**SECTION 4.55(1A) MODIFICATION APPLICATION – SSD 9670 MOD 3  
WESTERN SYDNEY UNIVERSITY INNOVATION HUB – 2-6 HASSALL STREET, PARRAMATTA**

This application has been prepared by Ethos Urban on behalf of Western Sydney University (applicant), pursuant to section 4.55(1A) of the Environmental Planning and Assessment Act 1979 (EP&A Act) to modify Development Consent SSD 9670 relating to the Western Sydney University Innovation Hub at 2-6 Hassall Street, Parramatta (the site).

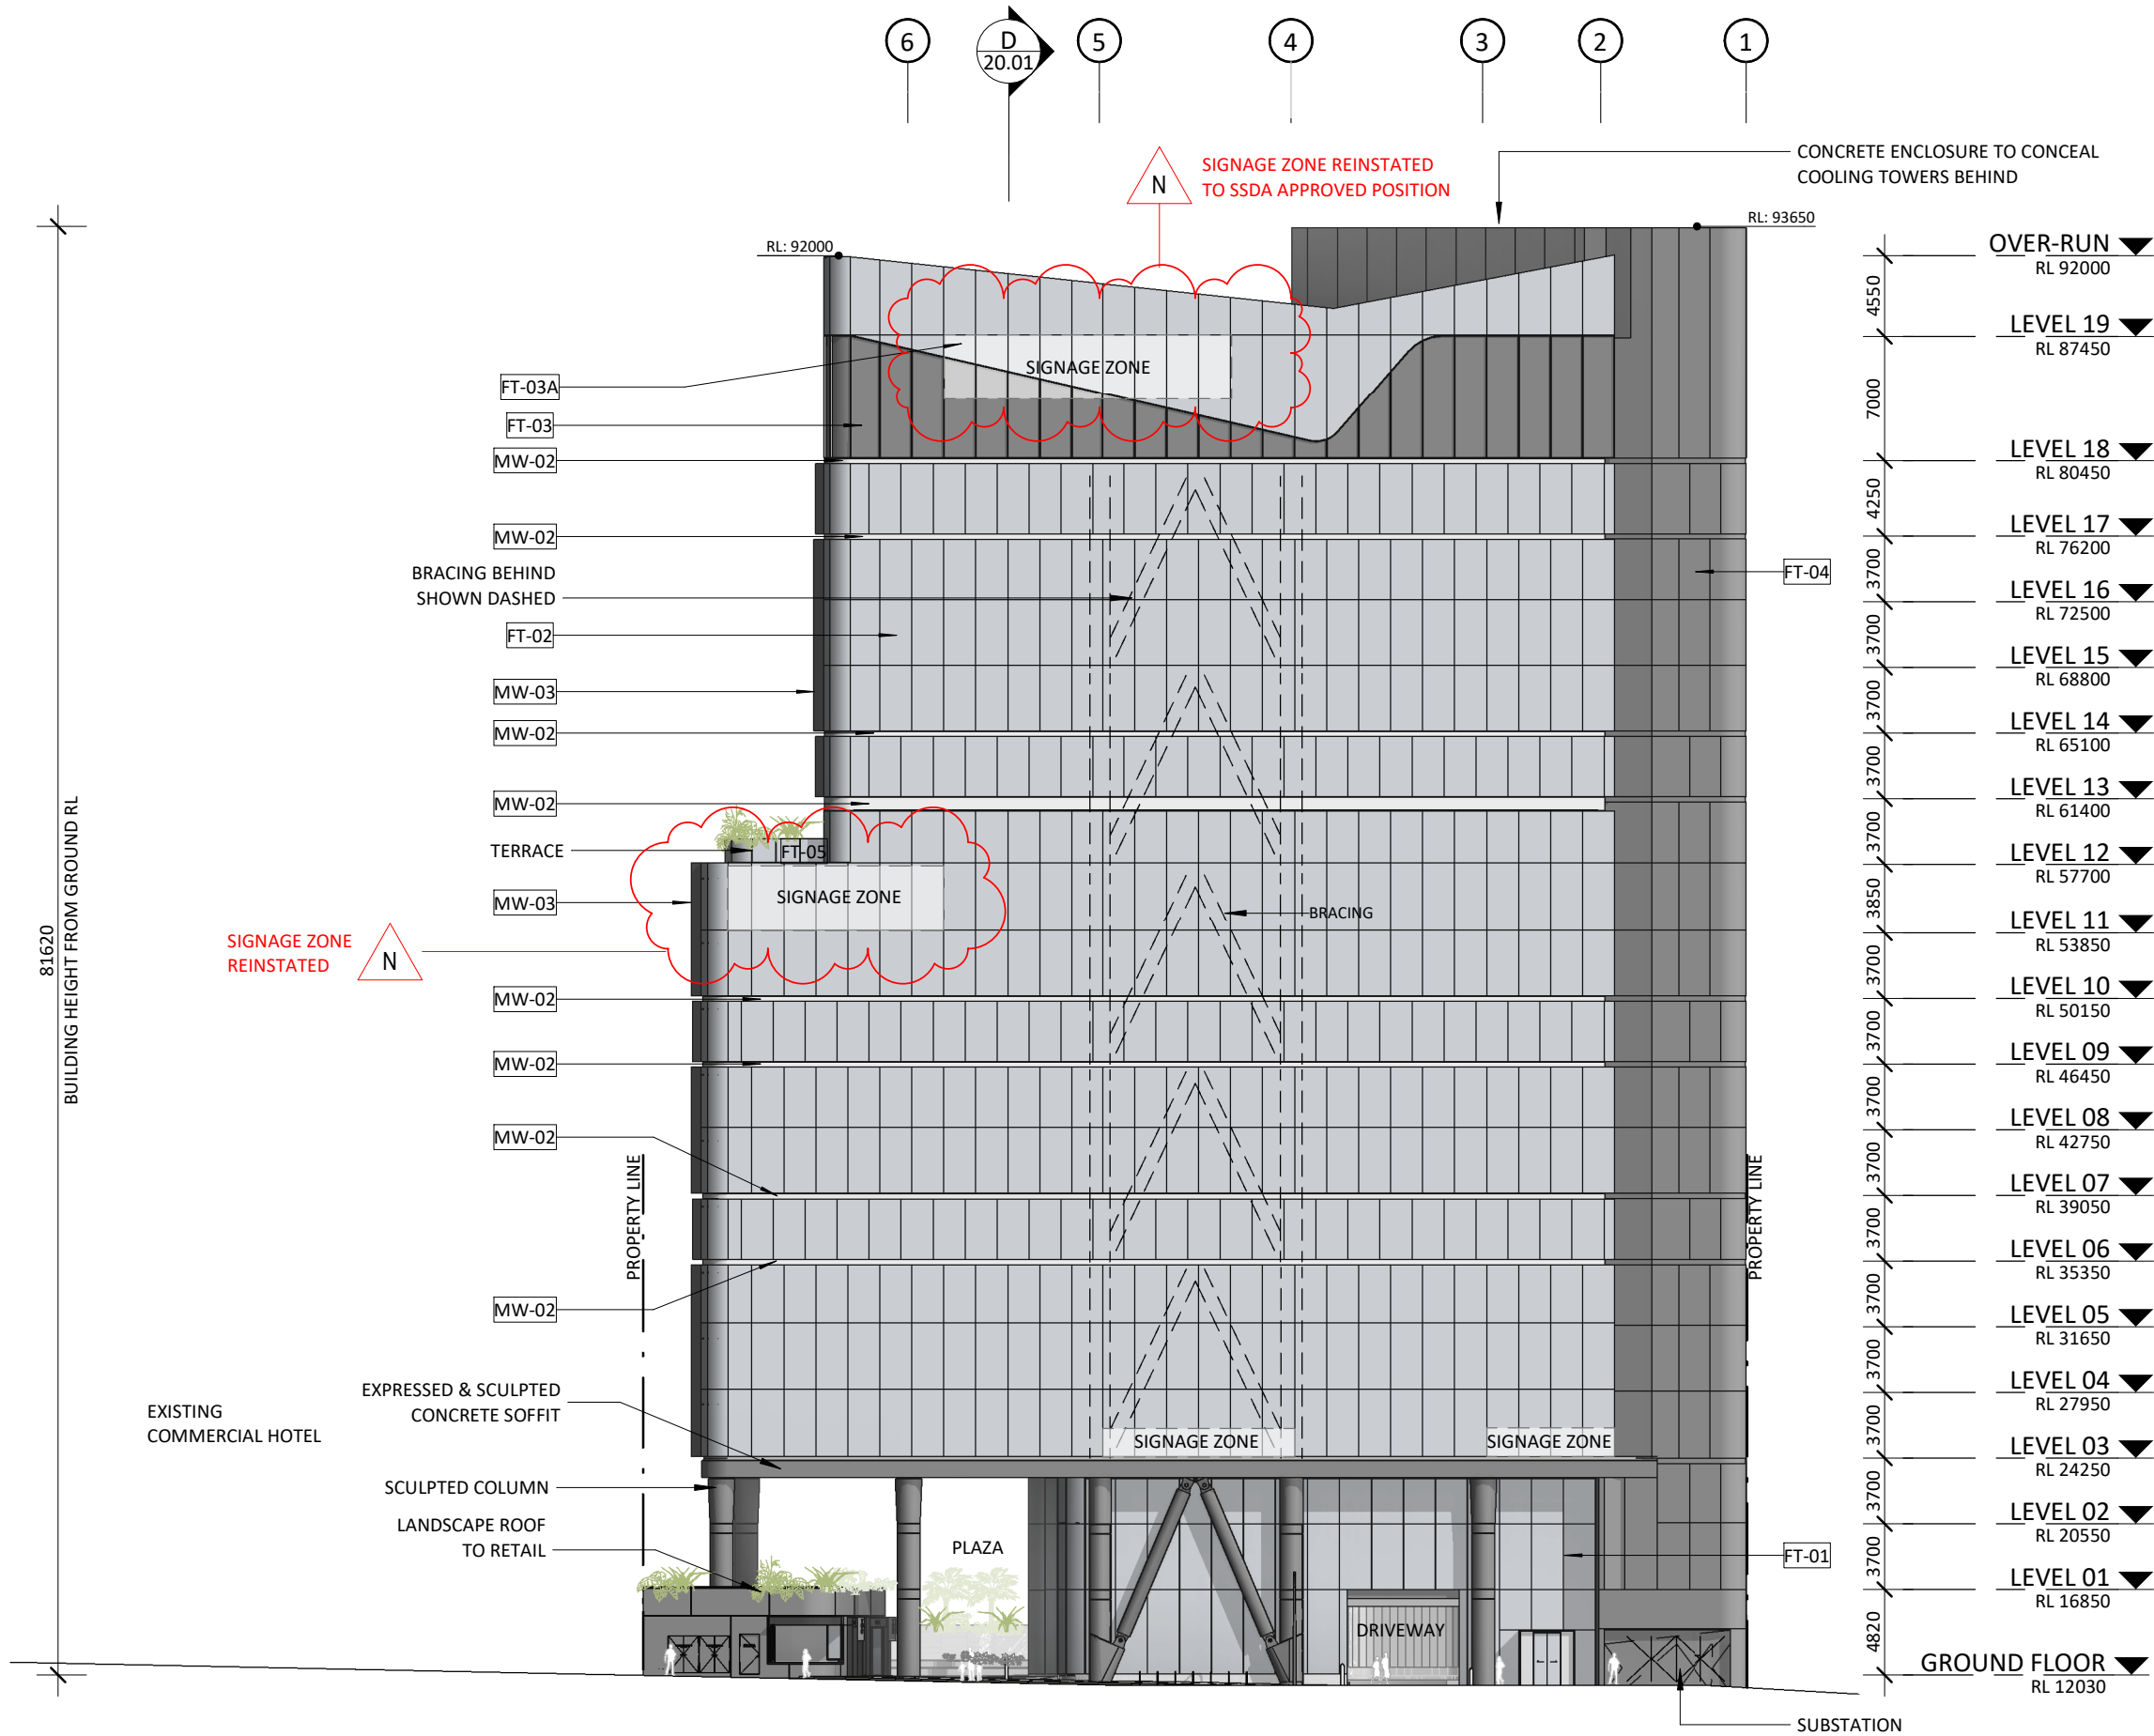
- Two (2) on the Western Elevation, comprising one within the building parapet and the second within the mid-rise section; and
- One (1) on the Southern Elevation within the mid-rise section.

Architectural Plans prepared by Tzannes Blight Rayner			
Dwg No.	Rev	Name of Plan	Date
30.02	<del>L</del> <b>N</b>	South Elevation	<del>09.08.2019</del> <b>24.06.2020</b>
30.03	<del>L</del> <b>N</b>	West Elevation	<del>09.08.2019</del> <b>24.06.2020</b>

**Reason:** The above drawing is proposed to be replaced to reinstate three (3) building identification signage zones and amend one (1) further signage zone.

Sheet Name  
**SOUTH ELEVATION**

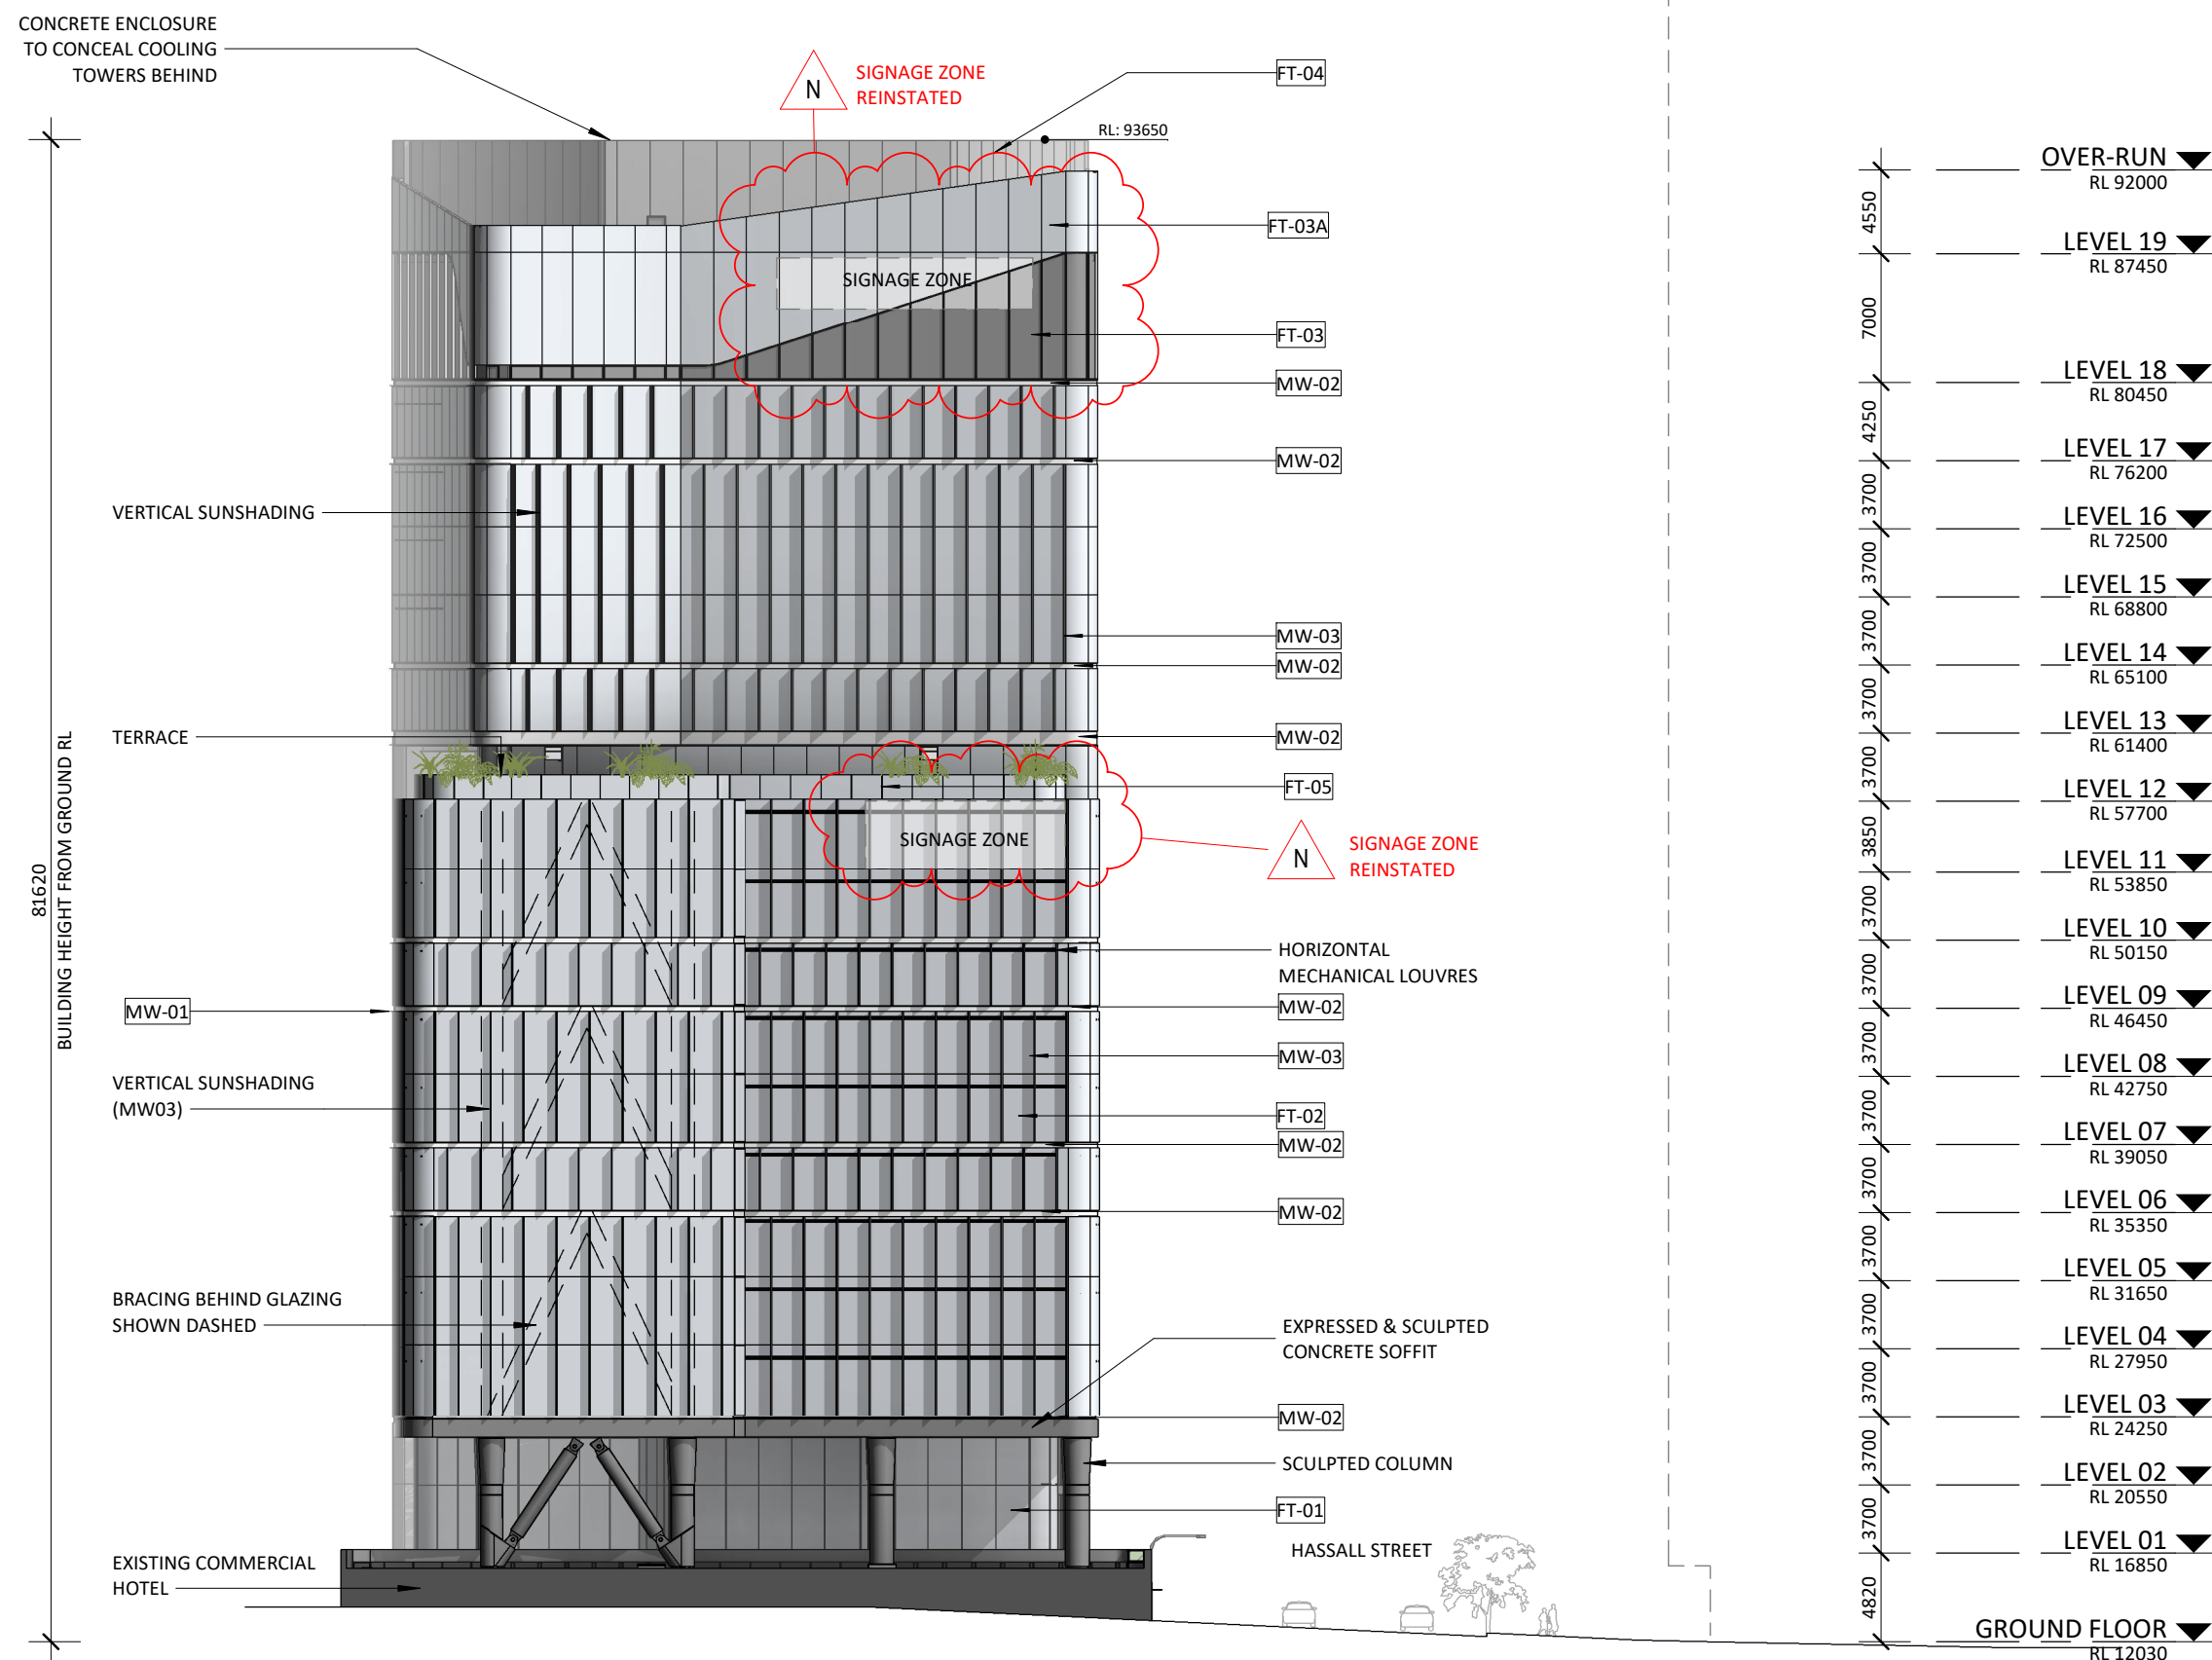
These signage zones were originally included on the architectural plans at the time of lodgement, but due to a drawing error were omitted at the time of preparing the 'Response to Submissions' package. In addition, the top of building signage zone on the Southern Elevation is proposed to be adjusted to the size and location originally approved (previously altered as part of MOD2).
